**KIRKLEES METROPOLITAN COUNCIL  
INVESTMENT & REGENERATION SERVICE**

Reference No:	<b>2024/62/93114/W</b>
Site Address:	21, Darnley Close, Meltham, Holmfirth, HD9 4BT
Description:	Demolition of existing garage and link structure and erection of two storey side extension with external alterations
Recommending Officer:	Joshua Merriman

## HOUSEHOLDER DELEGATED REPORT

Drawing Title: **PROPOSED FLOOR PLANS,
ELEVATIONS & SITE LAYOUT**

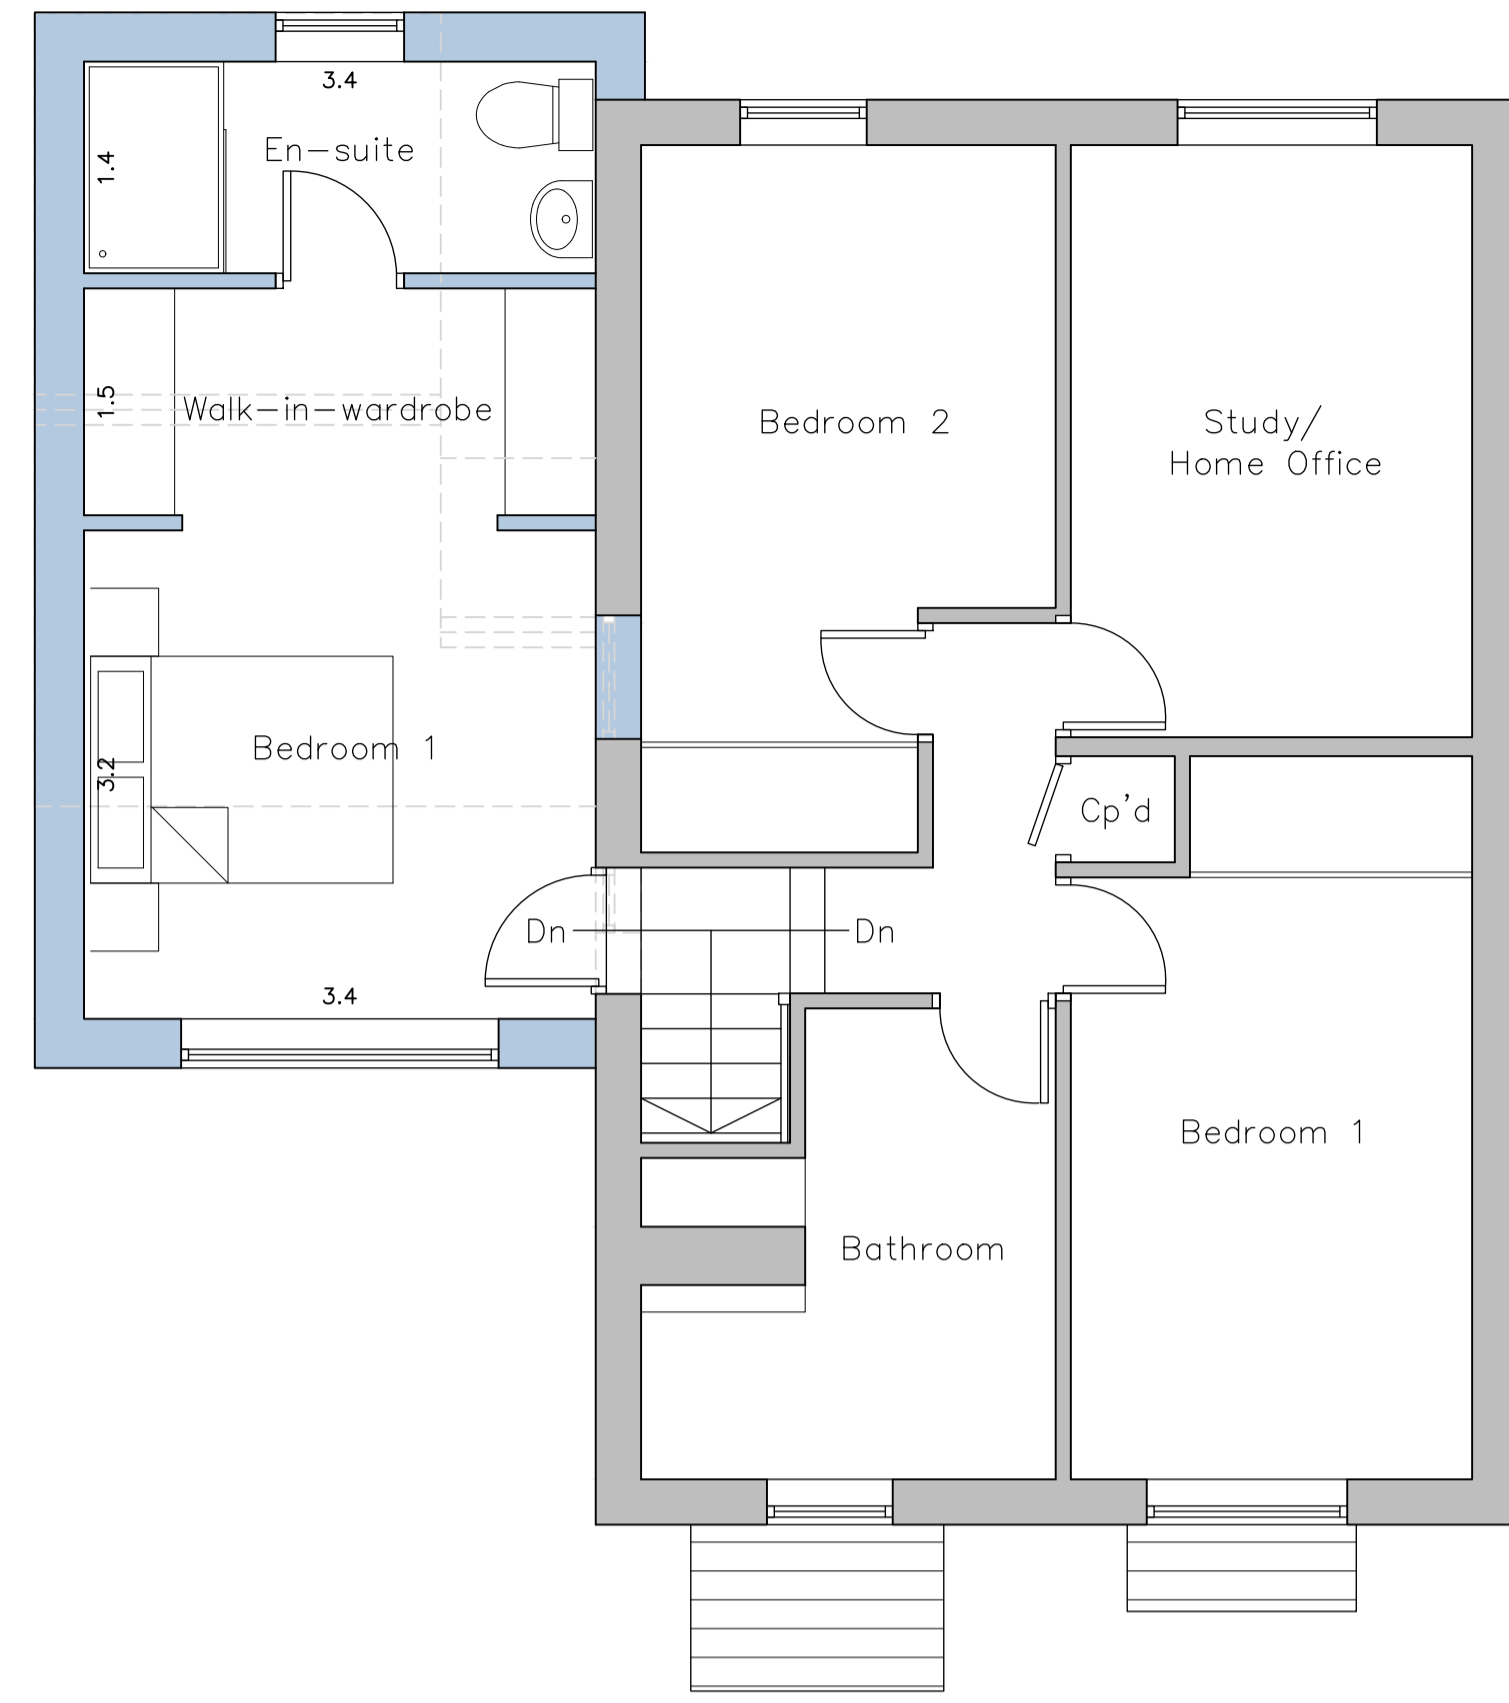
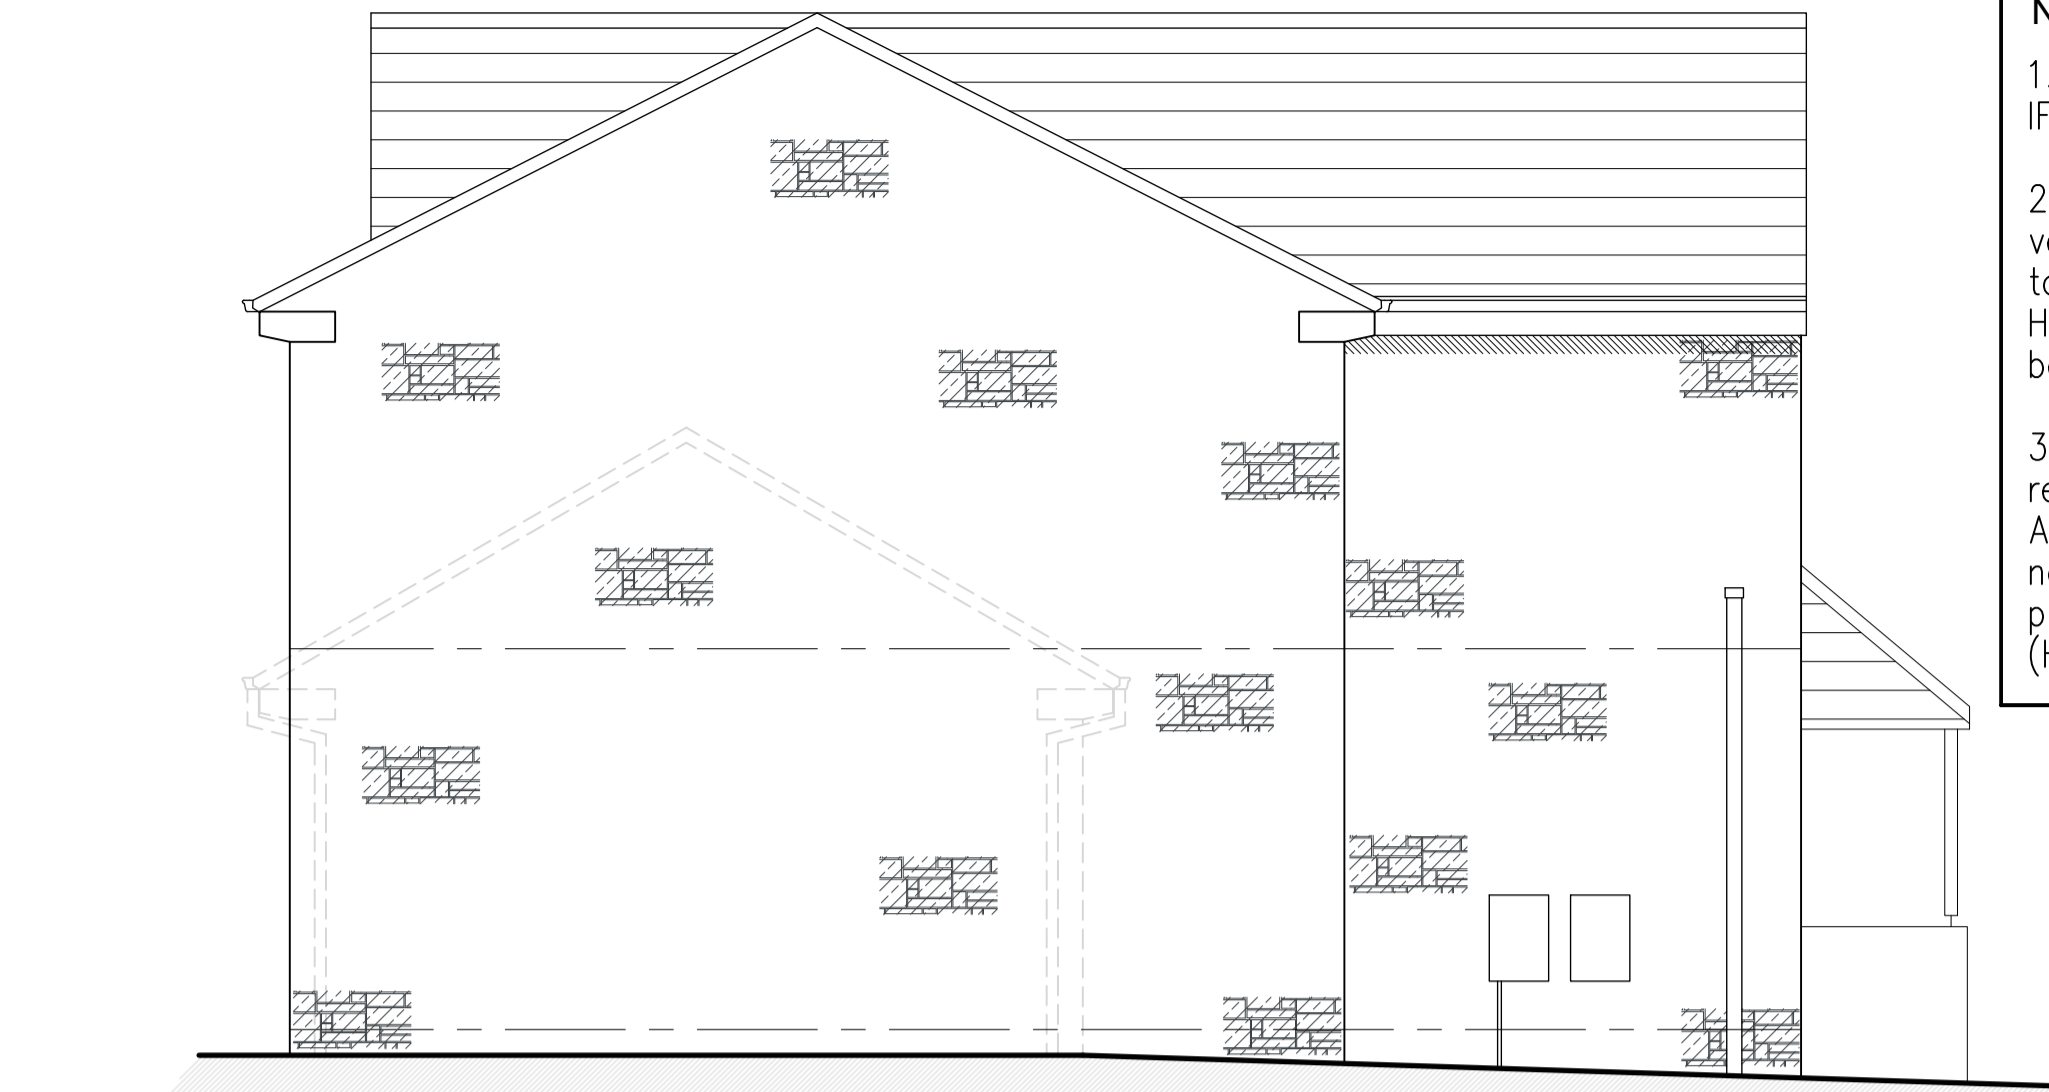
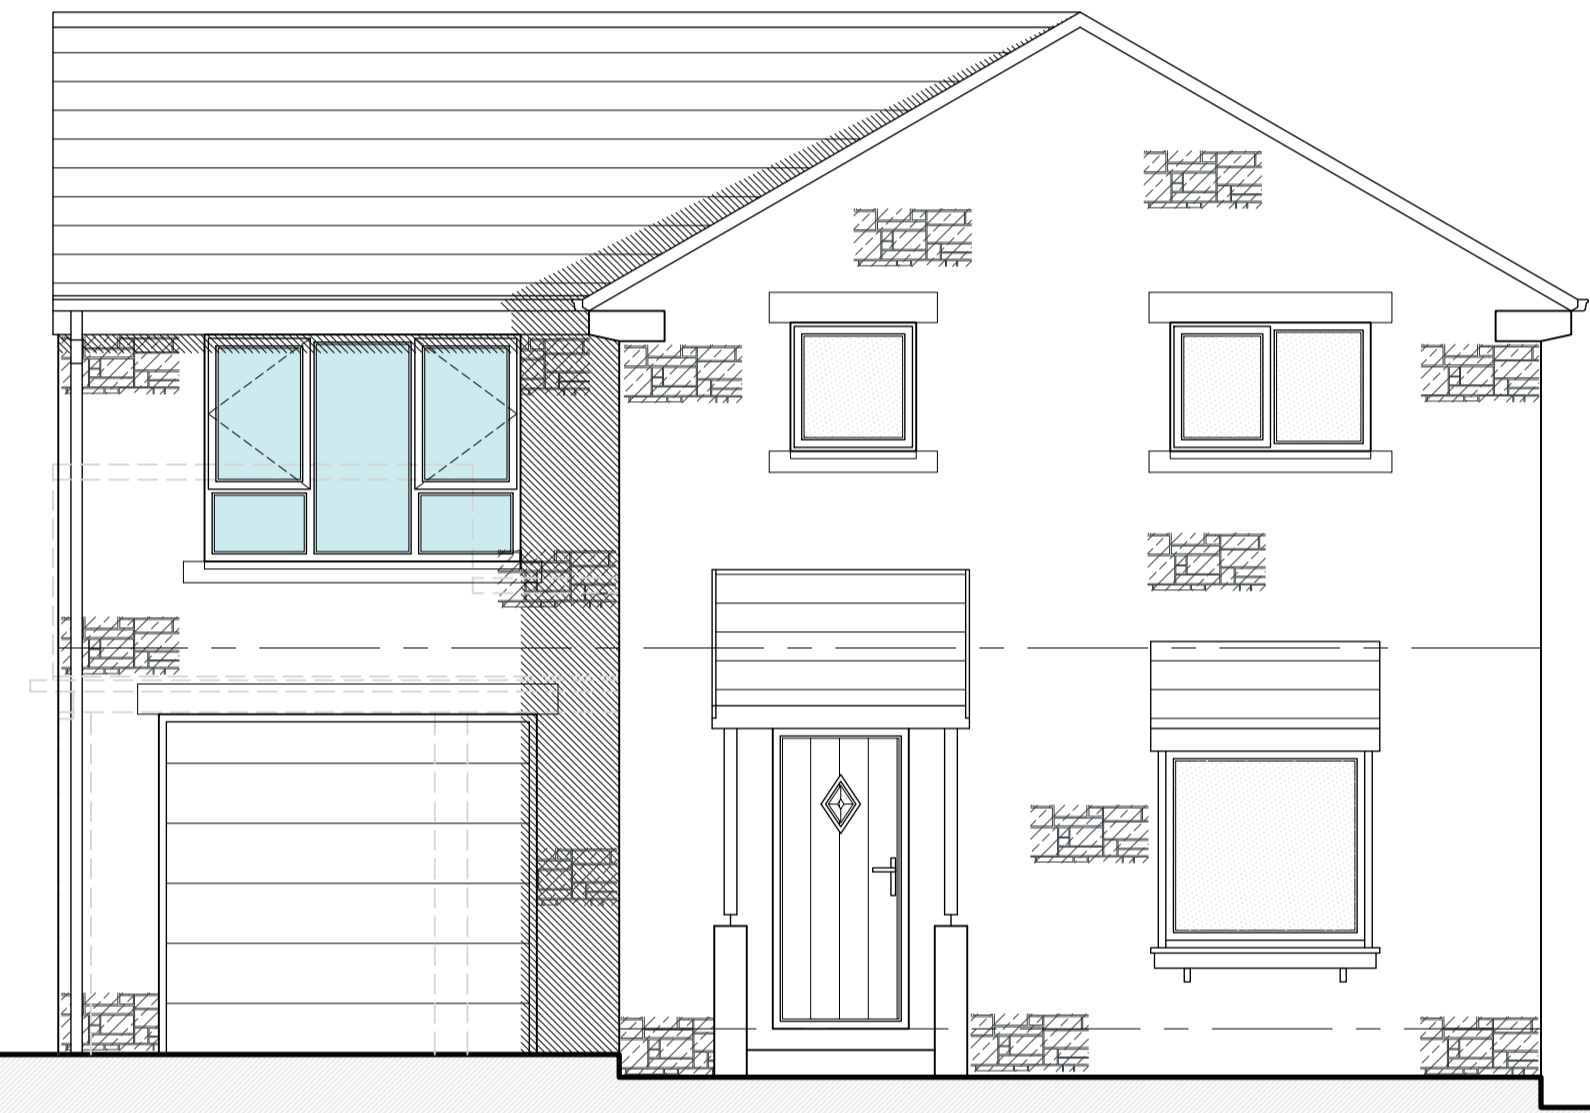
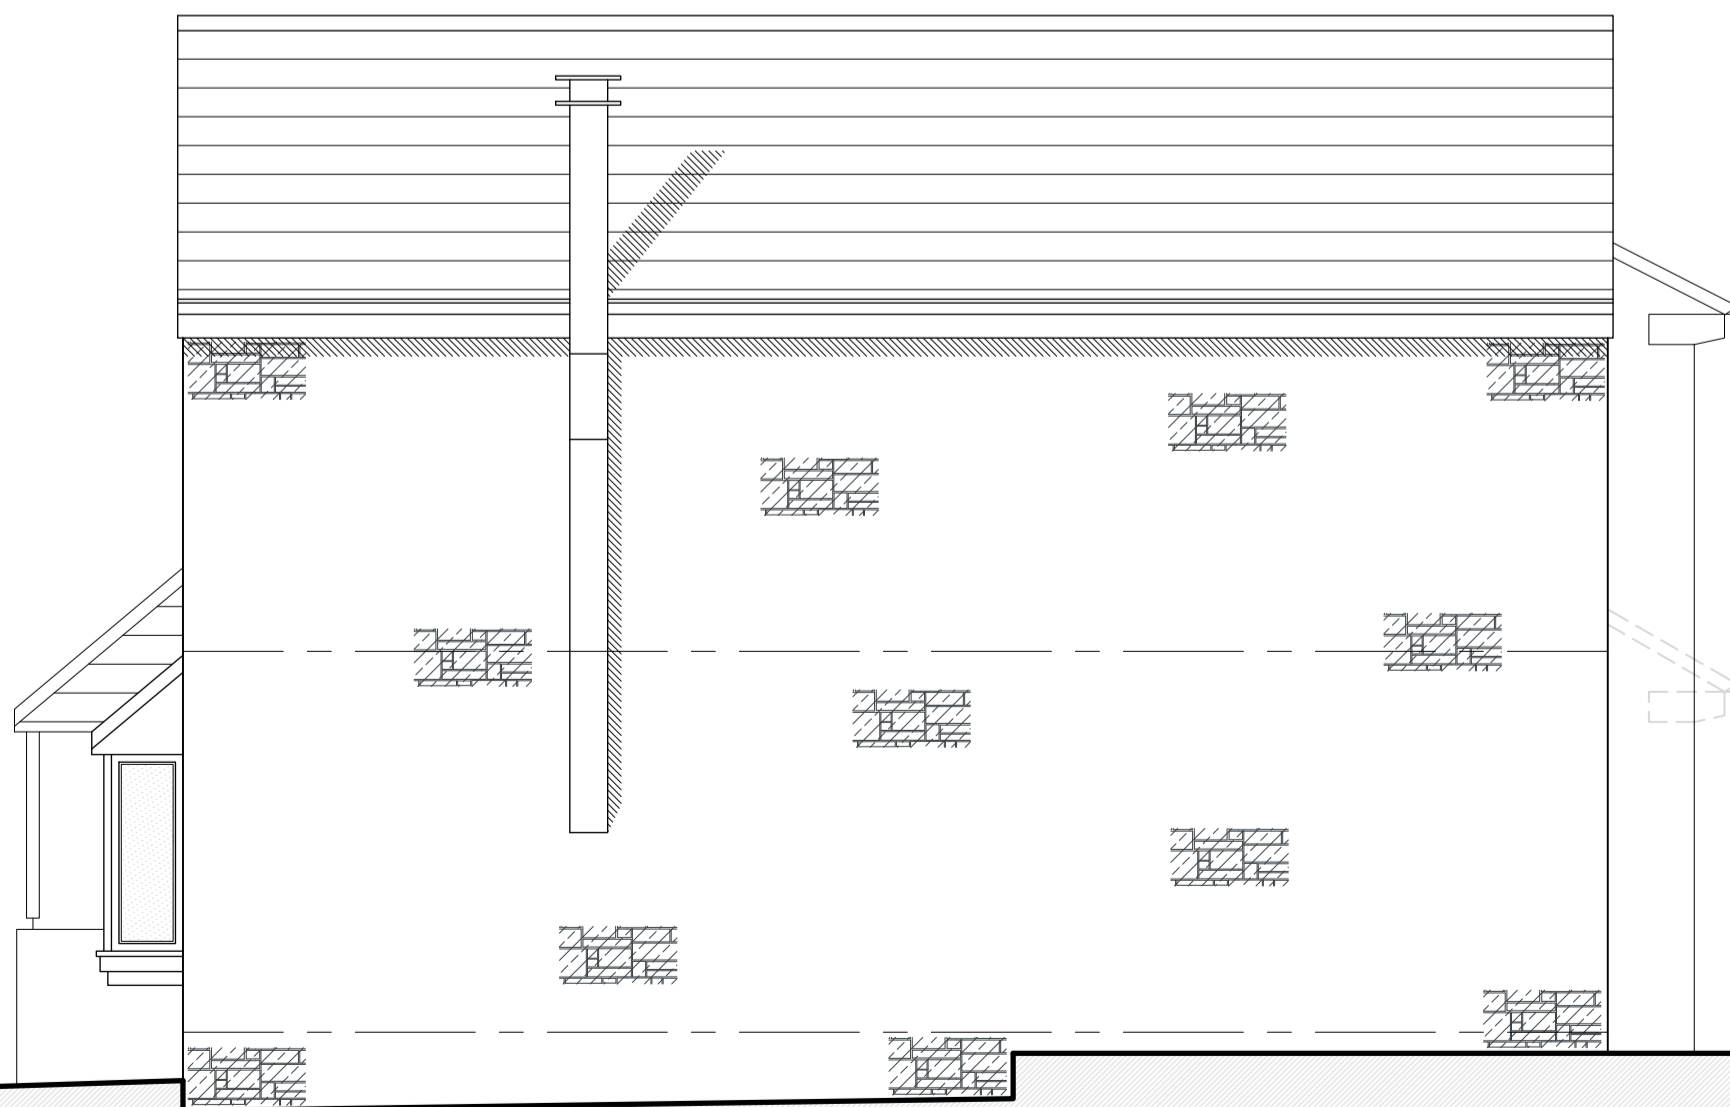
The application seeks permission for a two storey side extension. The proposed extension will project 3.74m from the side elevation of the existing building, the same distance as the current projection of the existing garage which is to be demolished as part of the proposal. The maximum height of the extension will be 6.89m, with an eaves height of 5m, and a depth of 6.94m.

<b>Two storey side extensions should:</b>		
Not take up all or most of the space to the side of a house	The proposed extension will leave the same space as is currently at the side of the property, therefore, no amenity space is lost as a result of the plans, and this is deemed acceptable.	
maintain a 1 metre gap to the side boundary to ensure the building is not too close to a neighbouring property		No gap is retained to the side boundary at the South of the property, however, external access to the garden is retained to the north of the dwelling, and there is still adequate space between the application property and neighbouring house for the extension to be acceptable.
be set back at least 500mm from the front wall of the house	The extension is set back 2.98m from the front wall of the original house.

Impact on the Local character and street scene	<ul style="list-style-type: none"> <li>• KDP1 of the SPD</li> <li>• Policy LP24 Design (a) and (c) of the KLP</li> <li>• Chapter 12 NPPF</li> </ul>	The materials proposed to construct the extension are all to match the existing building, and the proposed extension is therefore concluded to be subservient to the original building, therefore, it is considered that there will be no significant impact on the local character and street scene.	✓
Impact on original house	<ul style="list-style-type: none"> <li>• KDP2 of the SPD</li> <li>• Policy LP24 Design (c) and (d) of the KLP</li> <li>• Chapter 12 of the NPPF</li> </ul>	Due to the subservience of the proposed extension, and materials to match the existing house, there will be no significant impact on the original house.	✓
Height, scale and massing	<ul style="list-style-type: none"> <li>• KDP 1 and 2 of the SPD</li> <li>• Policy LP24 Design (a), (c) and (d) of the KLP</li> <li>• Chapter 12 of the NPPF</li> </ul>	The proposed side extension is subservient to the original house in terms of height, scale, and massing.	✓
